**Epping to Thornleigh Third Track Proposal.** Application number SSI 5132.

**4/** we object to the Epping to Thornleigh Third Track Proposal and consider that the EIS is inadequate and does not address the full impact of this proposal. It will cause untold damage to the health of residents and to the fabric of the Beecroft Cheltenham Heritage Conservation Area. Do not approve this project, reconsider the alternatives and protect the community.

Figure 5.6 Cross-section and elevation - New Cheltenham Station concourse building
Note: Indicatively added to future design

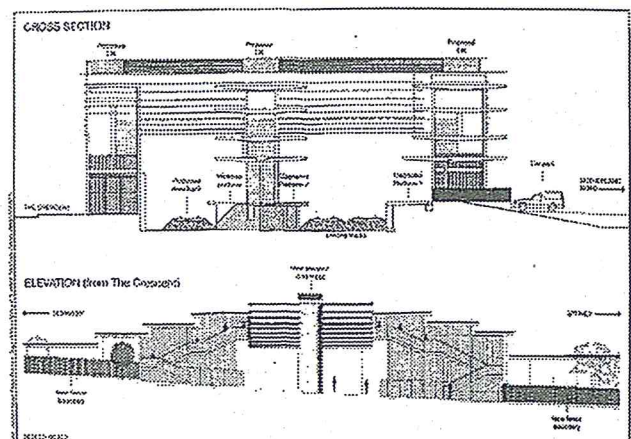
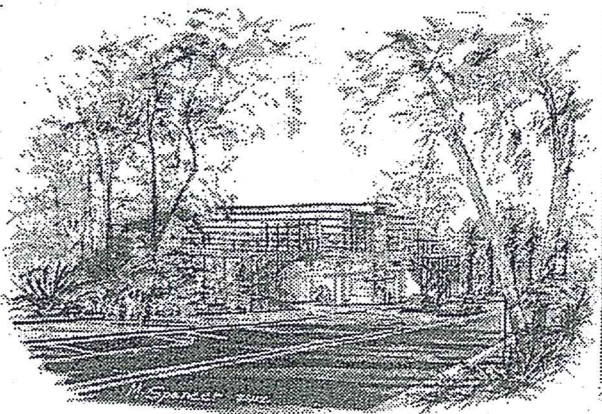
- The proposed redevelopment of Cheltenham Station shows no regard for the HCA. The visual impact of the proposed 13m high glass and steel concourse is totally unacceptable in this HCA.
